From: Richard Stefanski [redacted]
Sent: 29 January 2018 13:00 [redacted]
To: Amber Willard
Cc: Bruno Raworth
Subject: M/126/17/HH - 7 Alleyne Way Elmer Middleton on Sea PO22 6JZ

EXISTING WEST ELEVATION

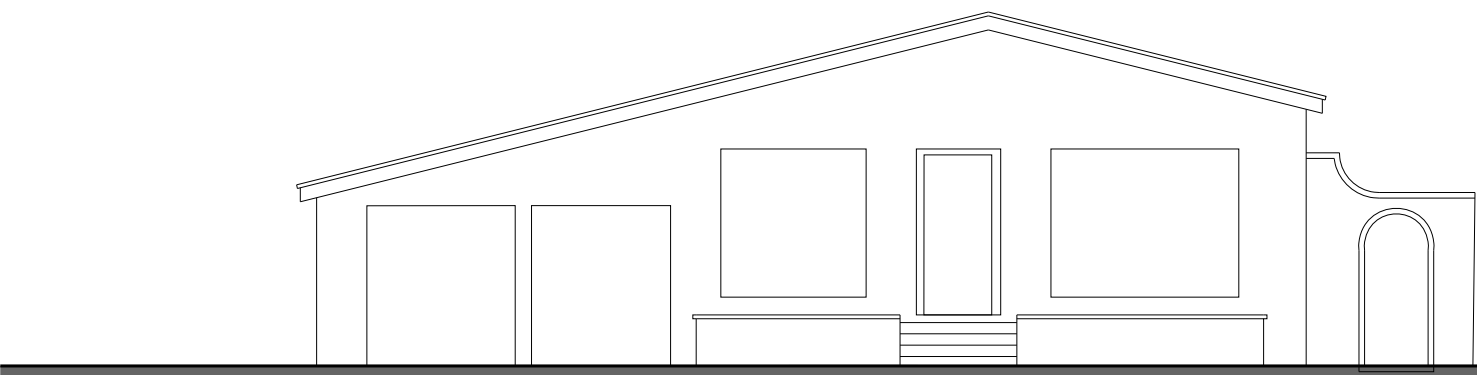
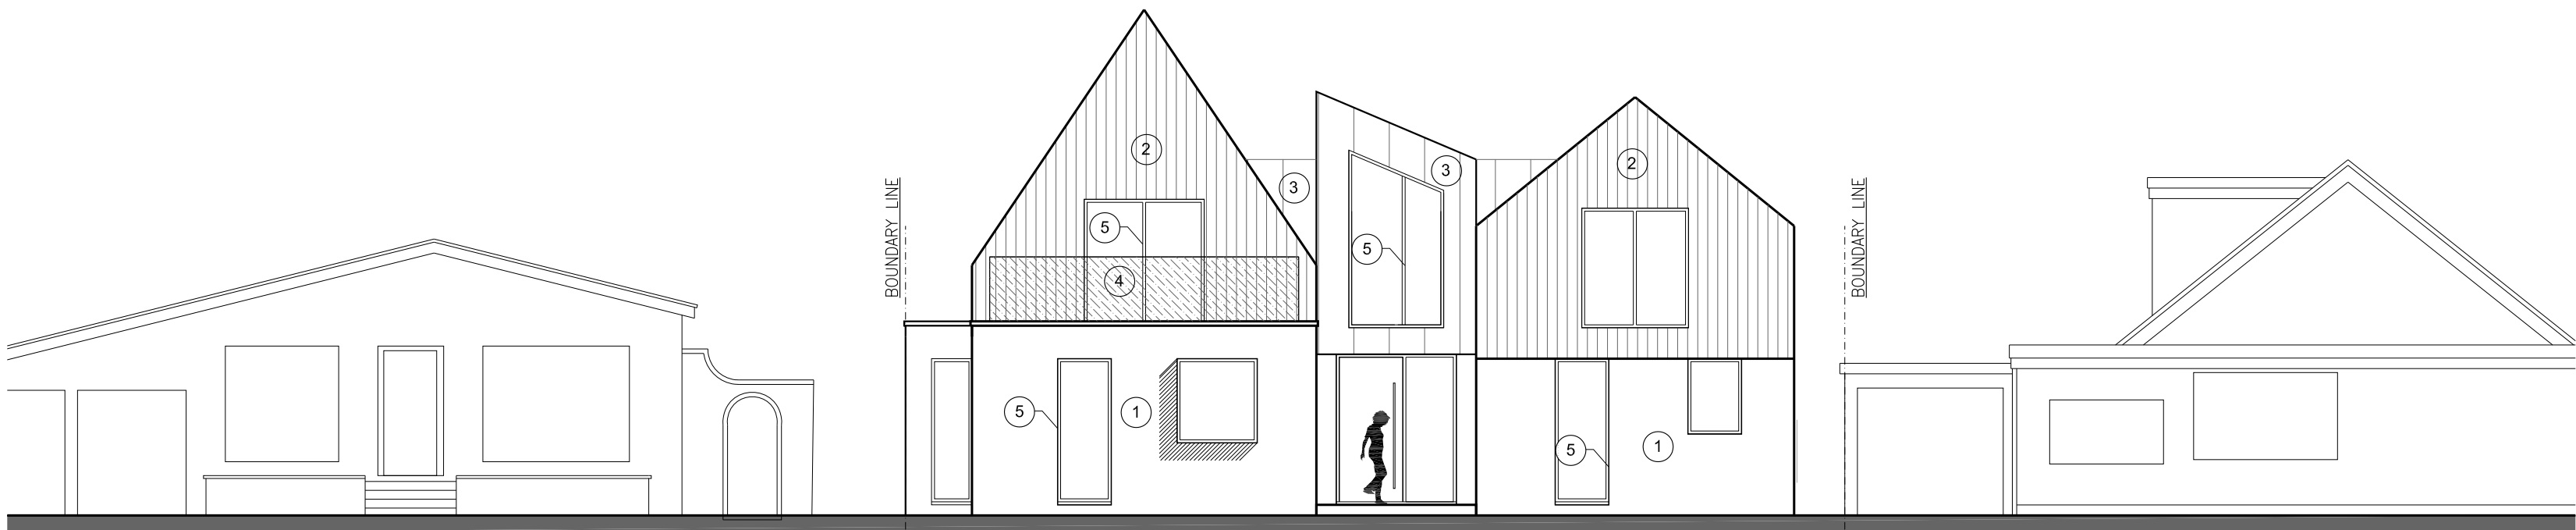
Please may you send a plan with the existing/ west elevation overlaid the proposed. This will give more clarity of the proposed changes to the roof.

PLOT PLAN - SCALE 1:500

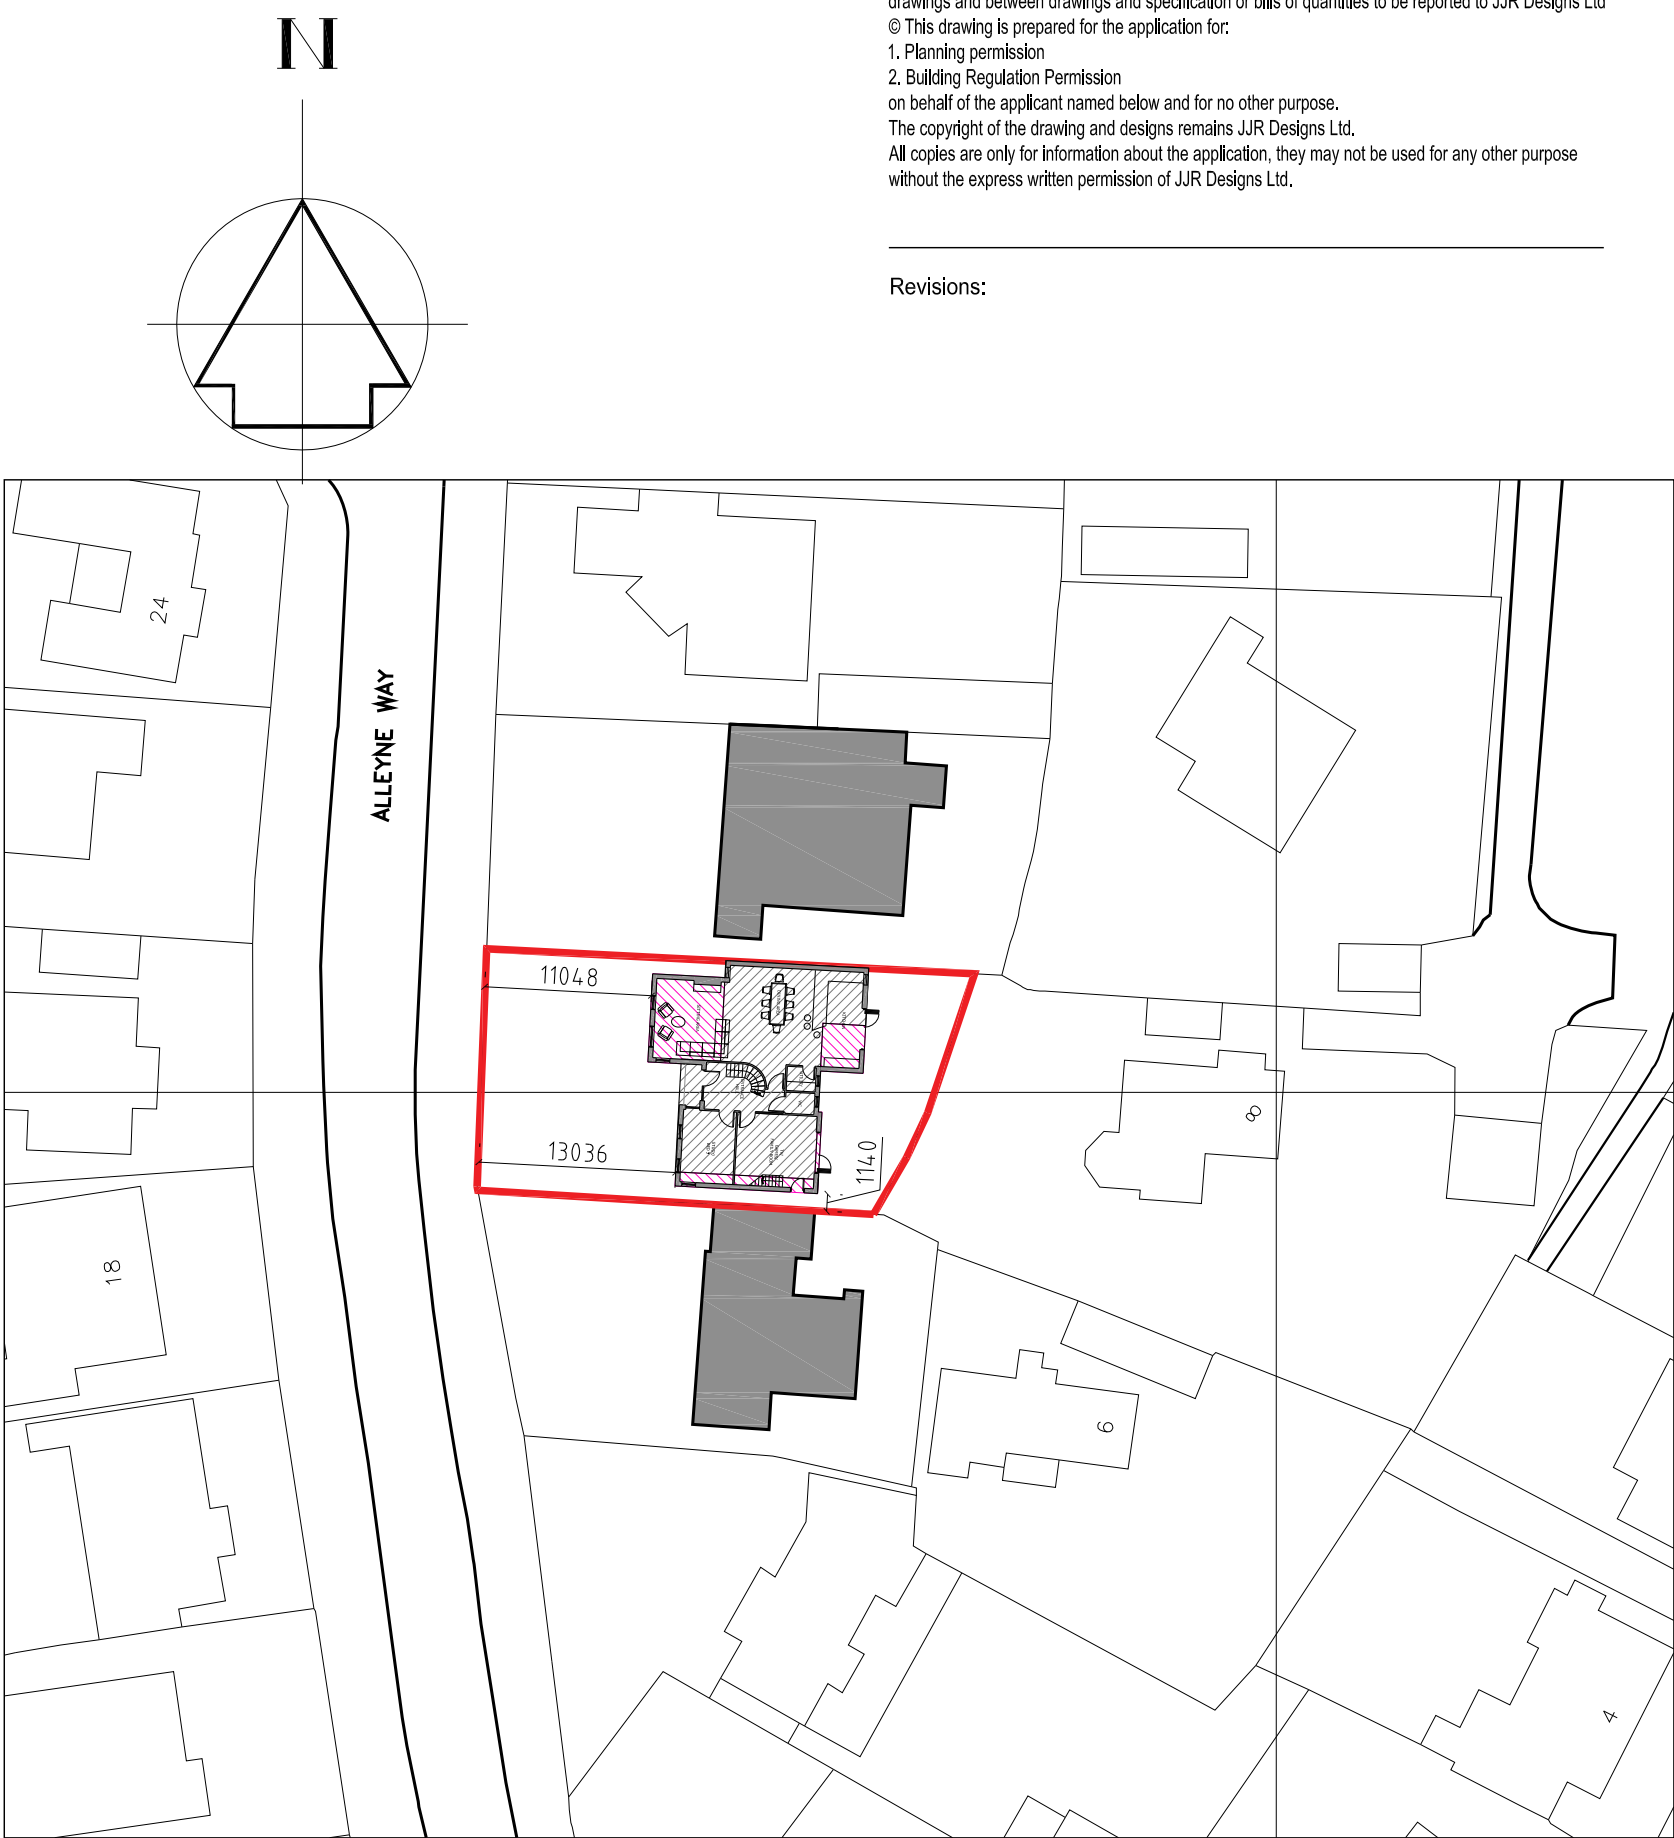
Please may you also confirm the distance that will remain on the south side from the proposed development to the boundary line.

I am concerned about the impact to the neighbours on the north side of the property and the potential for the loss of light. Also the distance from the proposed development to the boundary line on the south side of the property.

The distance from the southern boundary to the proposed extension is 1140mm.
